CM/34/21/PL

Change of use of part of site to car wash including siting of cabin and canopy. This application may affect the setting of a listed building & is in CIL Zone 5 (Zero Rated) as other development.

Maidenhead Aquatics Crookthorn Lane Climping BN17 5SN

project title
Car Wash at Maidenhead Aquatics Site
Littlehampton
drawing title
Elevations

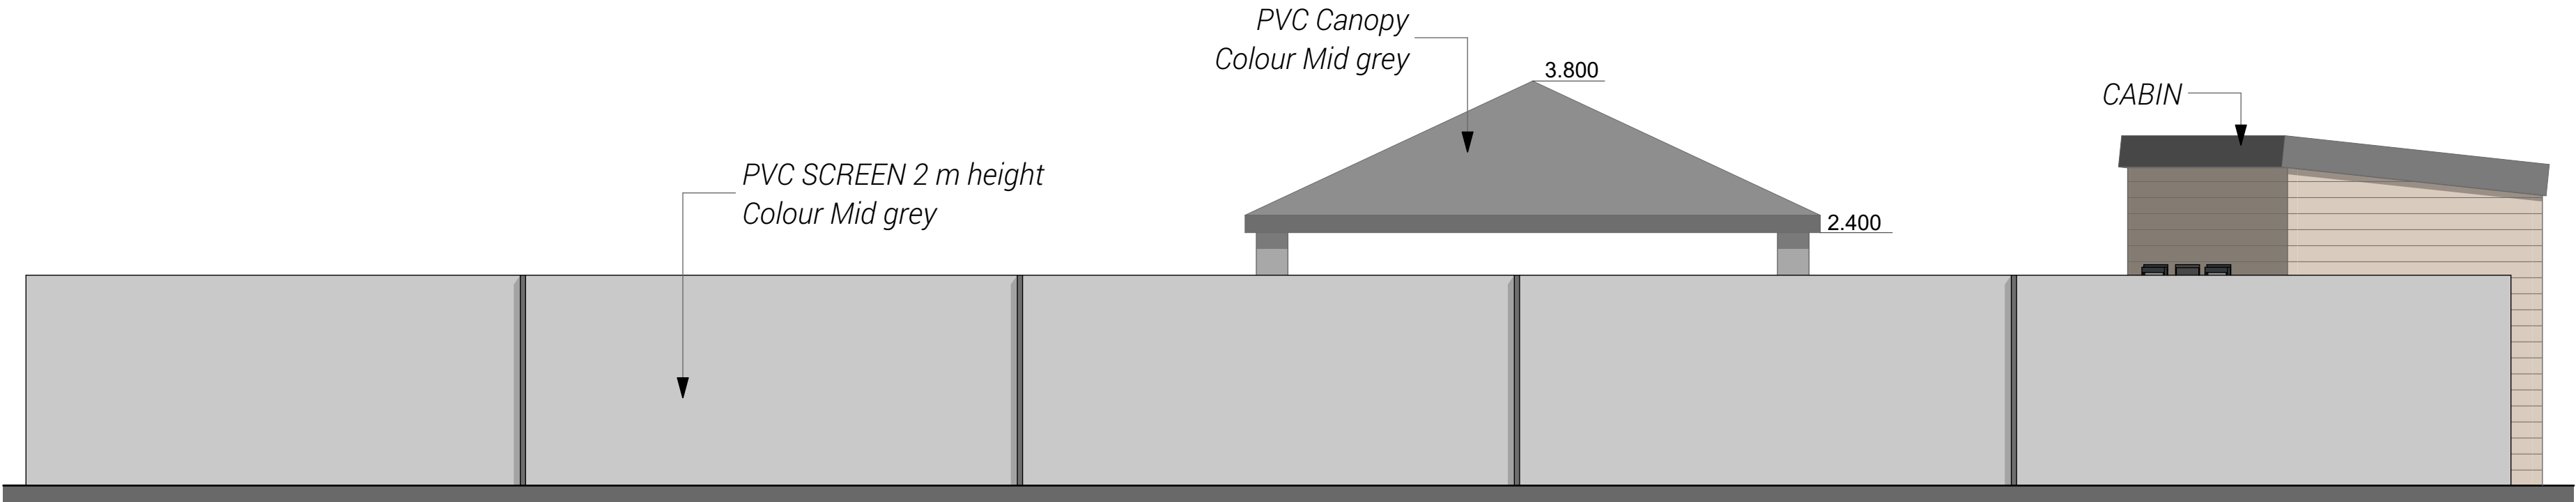
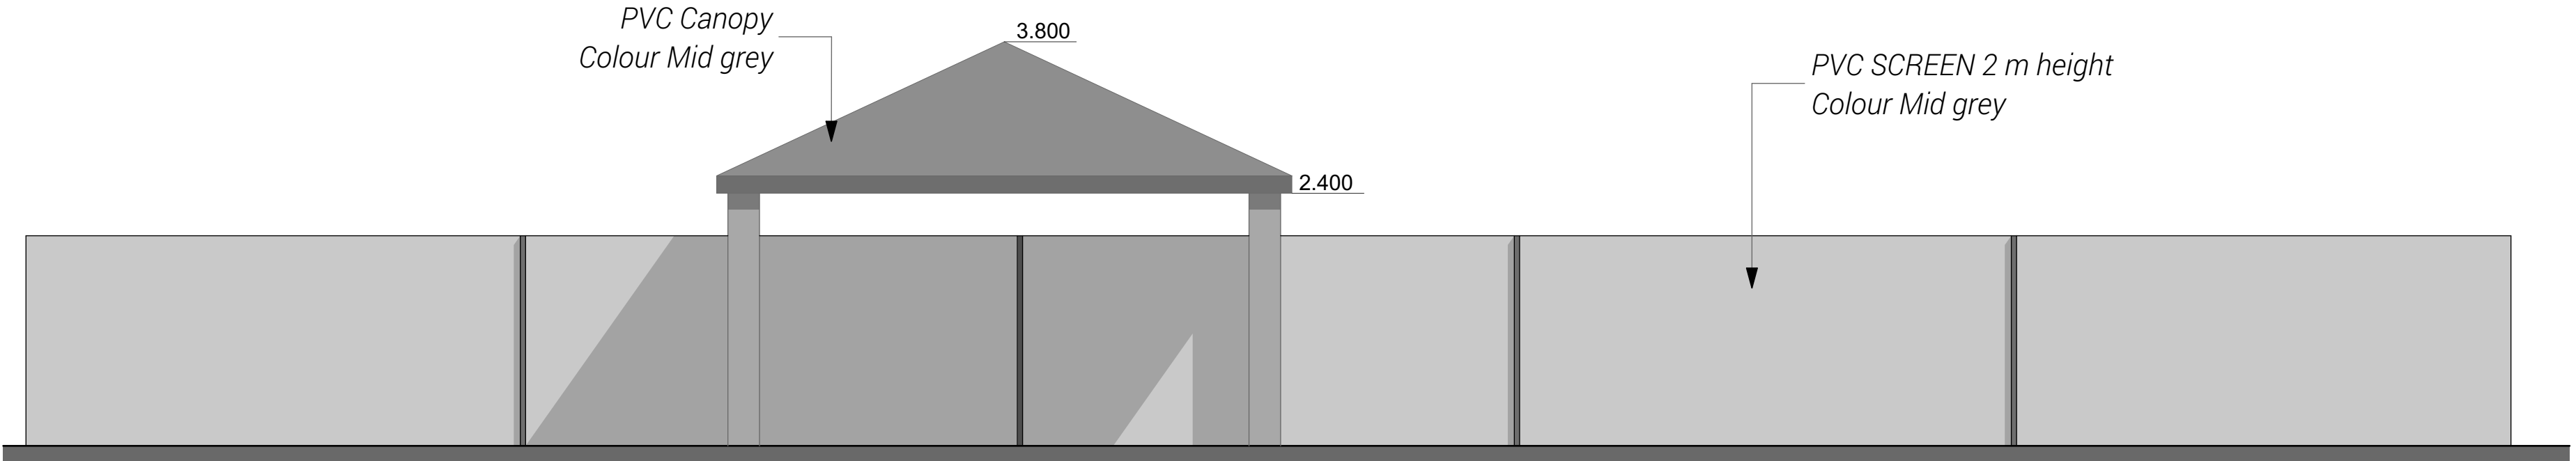
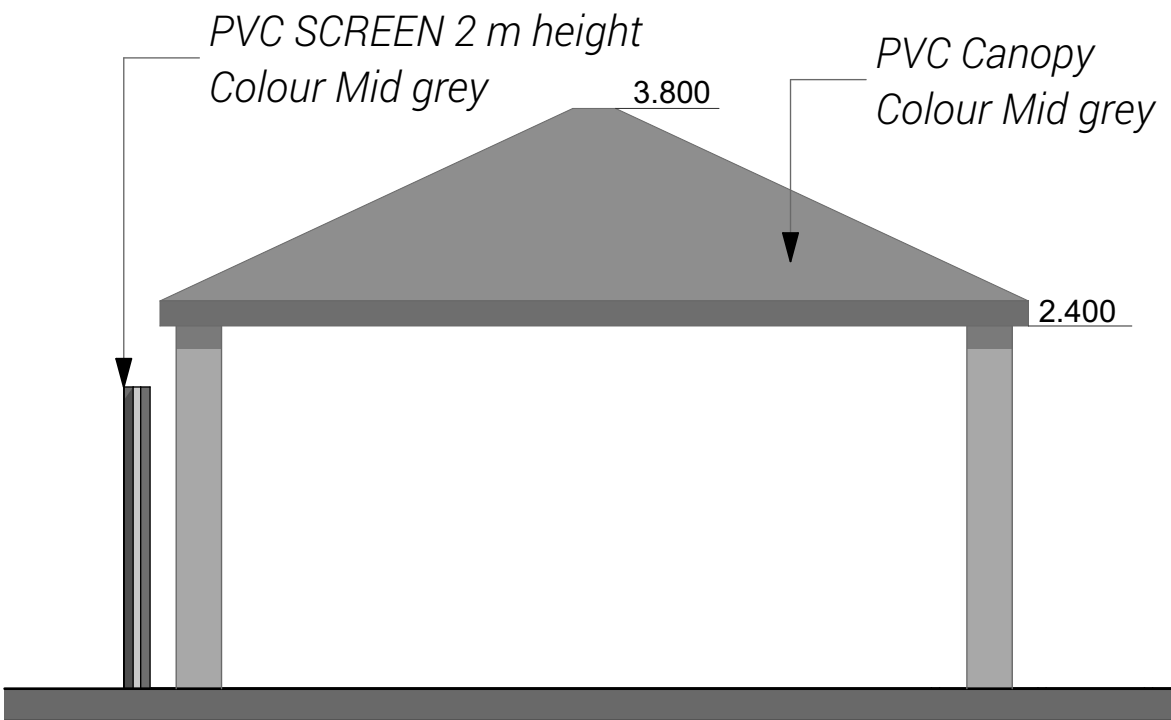
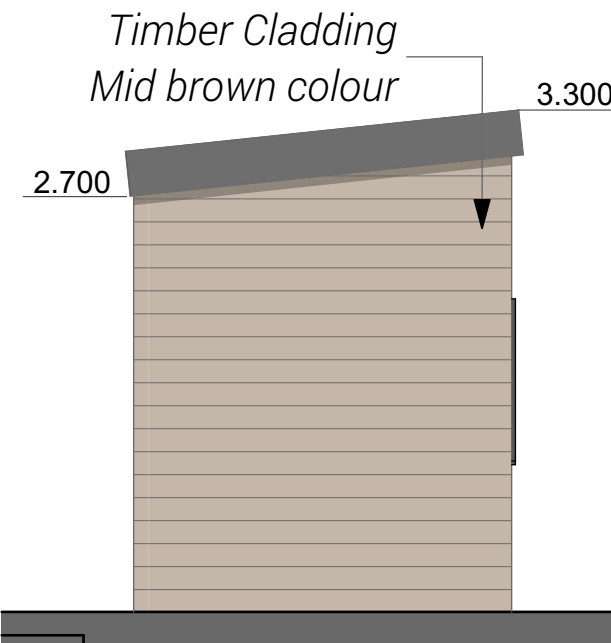
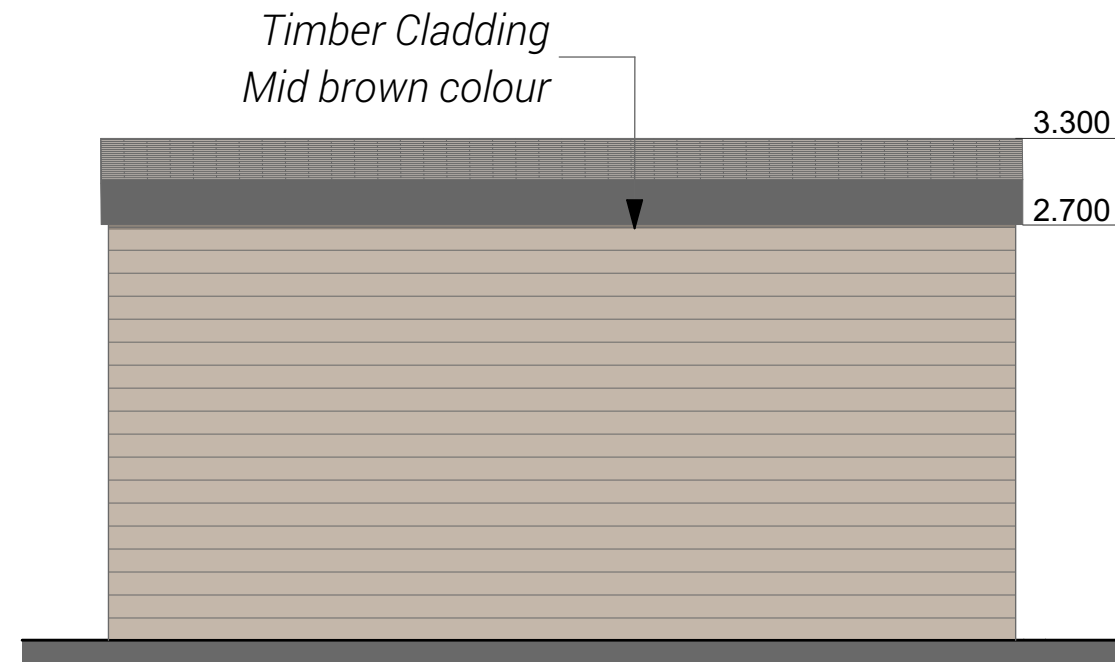
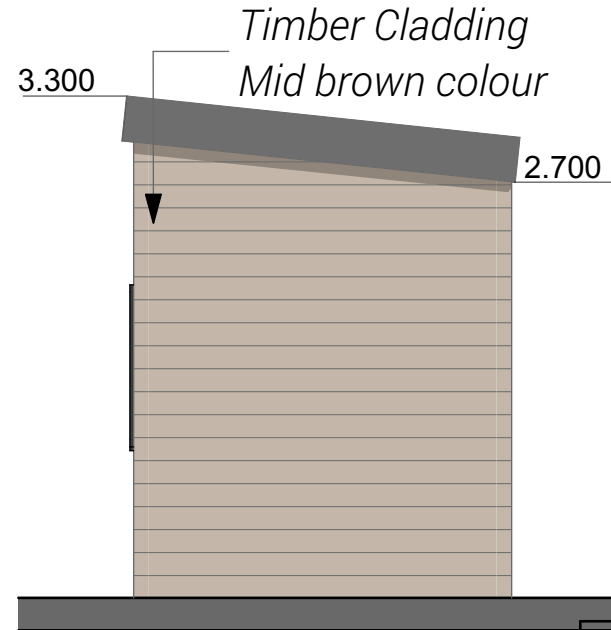
The application is for the Change of use of part of site to car wash including siting of cabin and canopy. It would appear that staff facilities would be accommodated within a small cabin, whilst there would also be a canopied area which provides shelter for car washing. I also note there is a proposed screen which would be visible from the A259. It would appear from my site visit that work has already started on implementing the application.

The new development will essentially expand the site with further built form which would introduce a more urban character to the local area, which at present has a more semi-rural feel with a lack of visible development, tree presence and a limited number of residential properties located a short distance away in The Street.

The cumulative impact of both this and the previous application would mean that the site as a whole would have a much more suburban character. The colours chosen for the development are also visually intrusive.
